Land in Churchfield Lane, Kexborough, Barnsley

A pre-application enquiry was submitted, 10 March 2014, the response was received, 23 April 2014.

Response, 23 April 2014, from LPA's Planning Officer:

Proposed Residential Development
3no. Three/Four Bedroom Houses
Churchfield Lane, Darton

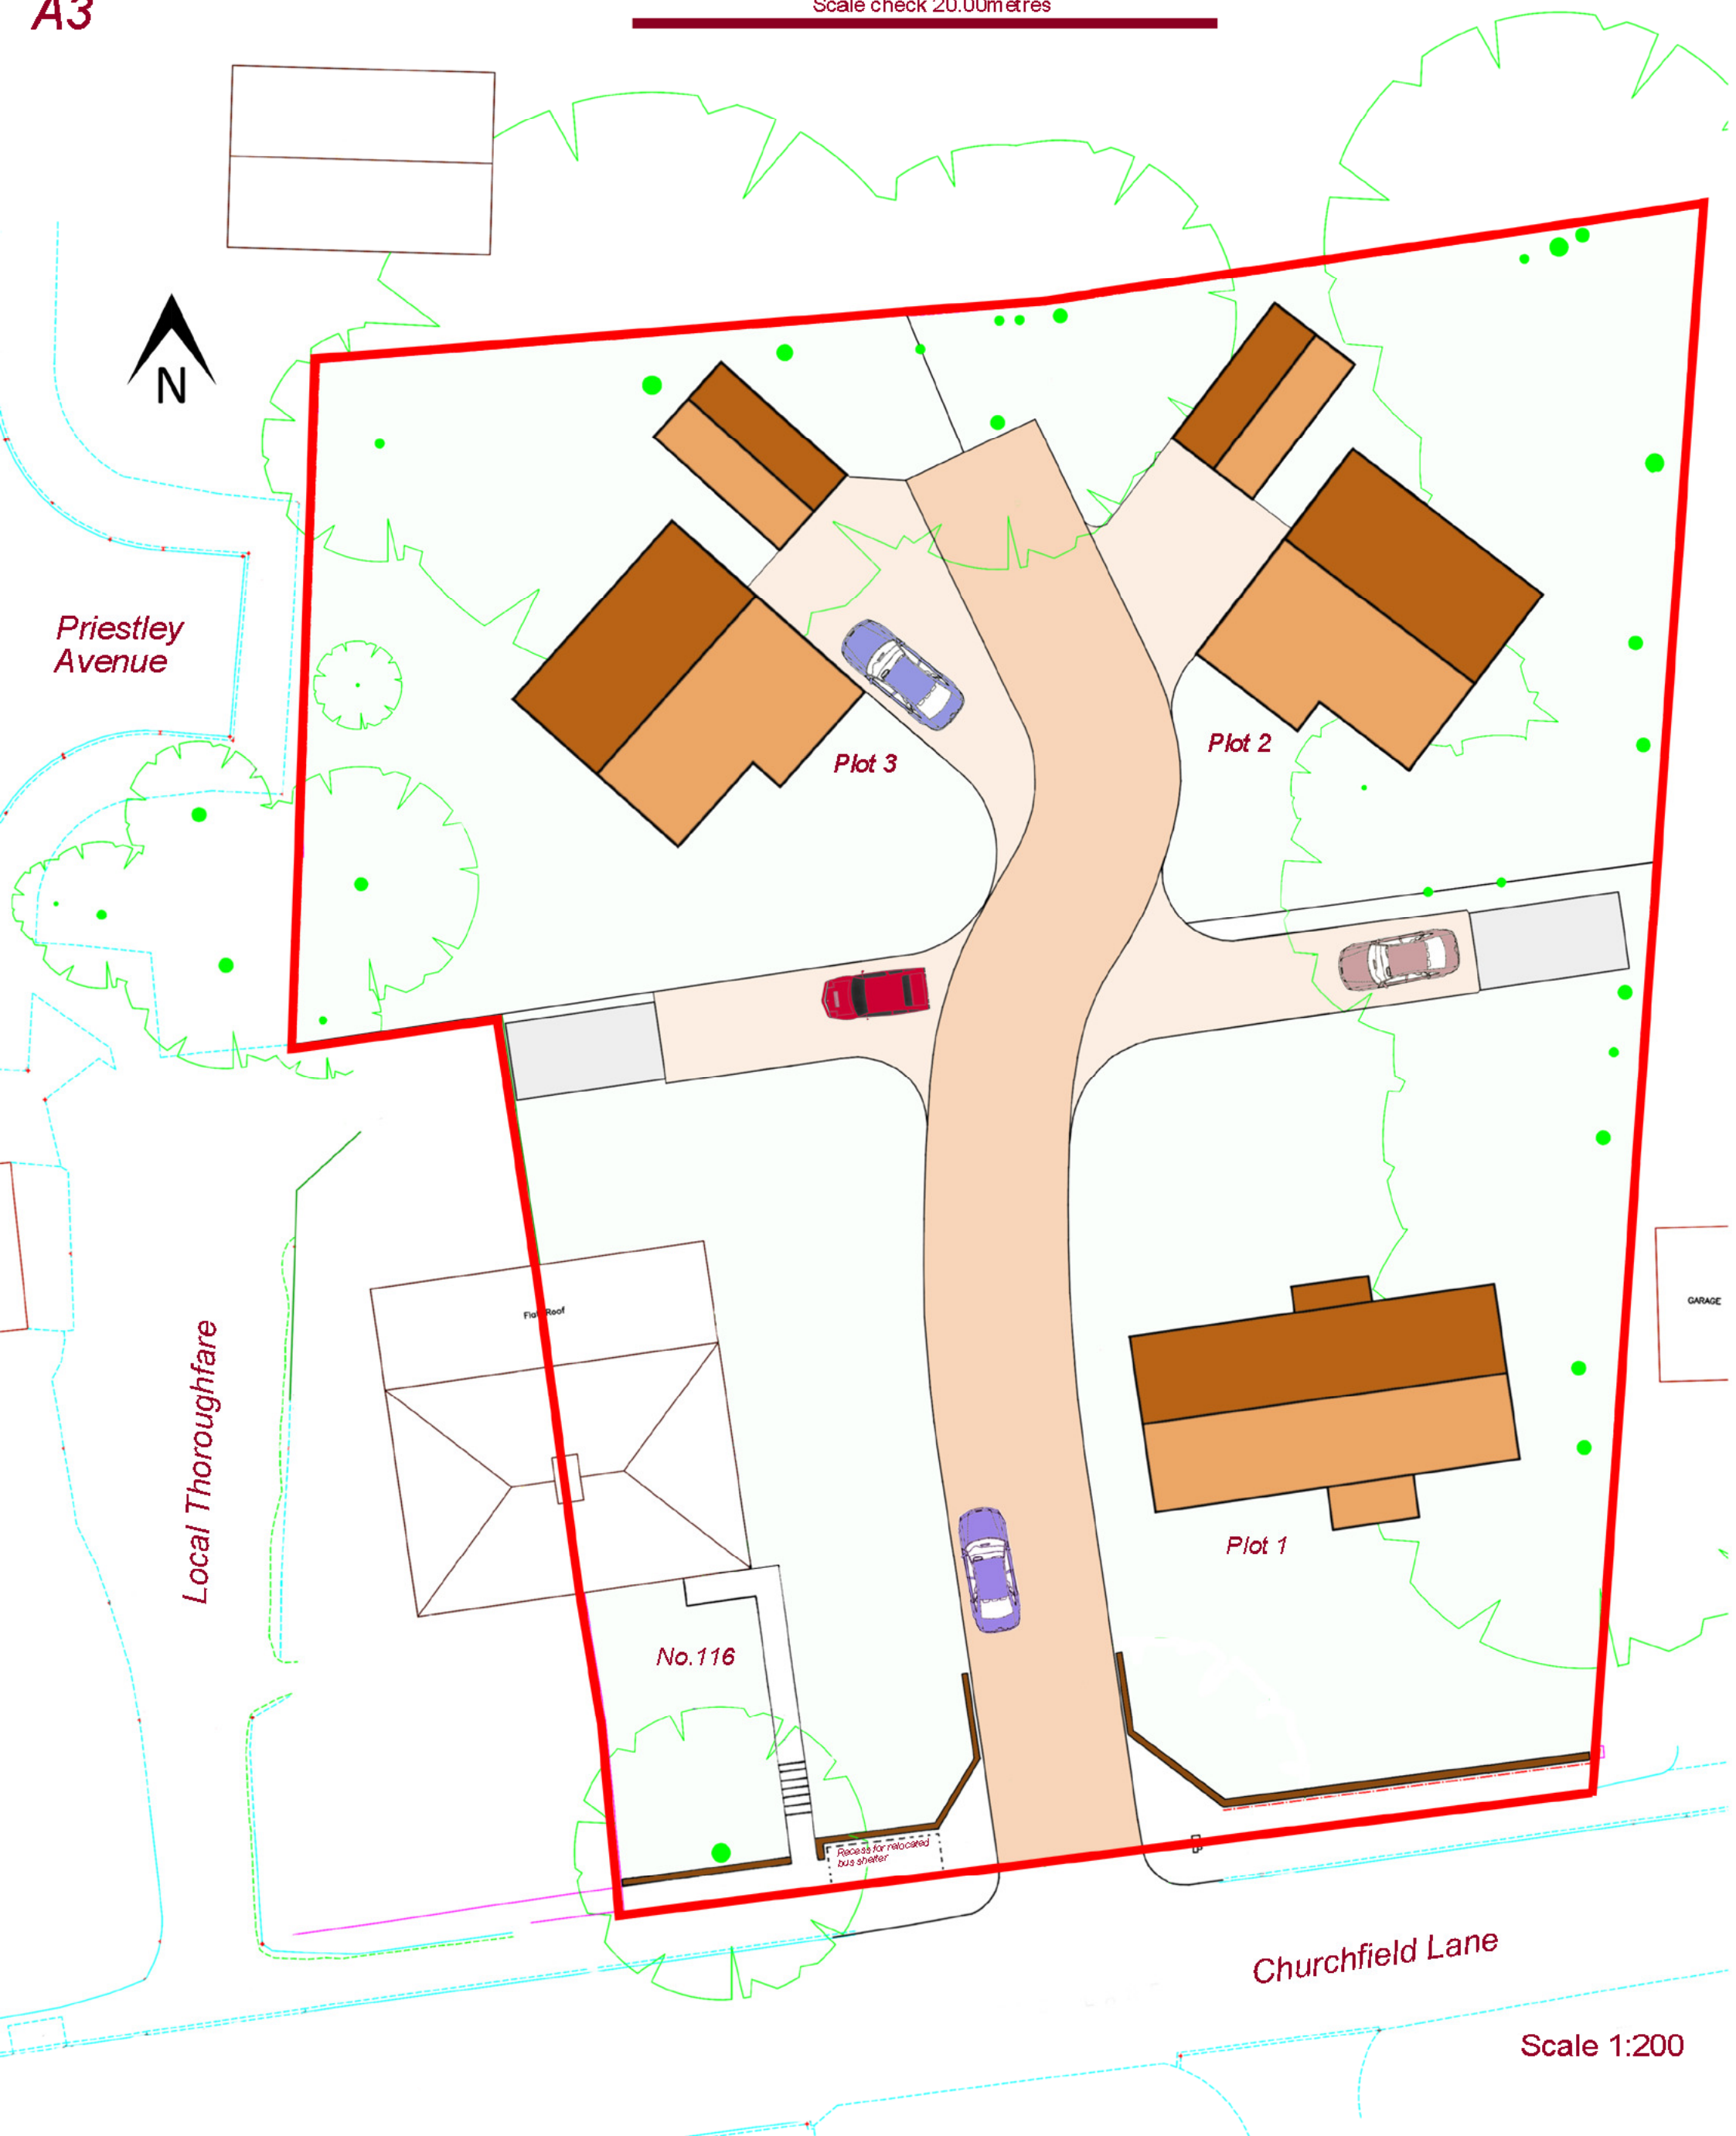
- A minimum of 21m would not be achieved between the rear of plot 4 (NB this is now Plot 3 on the submitted plan) and the existing dwelling located to the rear.

- A minimum 10m would not be achieved between the rear of plot 3 (Plot 2 on the submitted plan) and the boundary with the gardens of the properties located to the rear.

-The removal of garden land from 116 Churchfield Lane would mean that its private rear garden area would be below the minimum standard of 60m² for three bedroom properties.

In that regard, there are no windows on the south elevation of the dwelling that the planning officer is referring to, as such, the guidance note quoted above is not applicable

In order to address this concern the proposed house in the location referred to, has been rotated by approximately 15 degrees, which renders the windows on its north-east elevation in excess of the min. 10.0m guidance.

The revised scheme results in a significantly larger plot allocated to No.116 and the planning officer's observation therefore no longer applies.
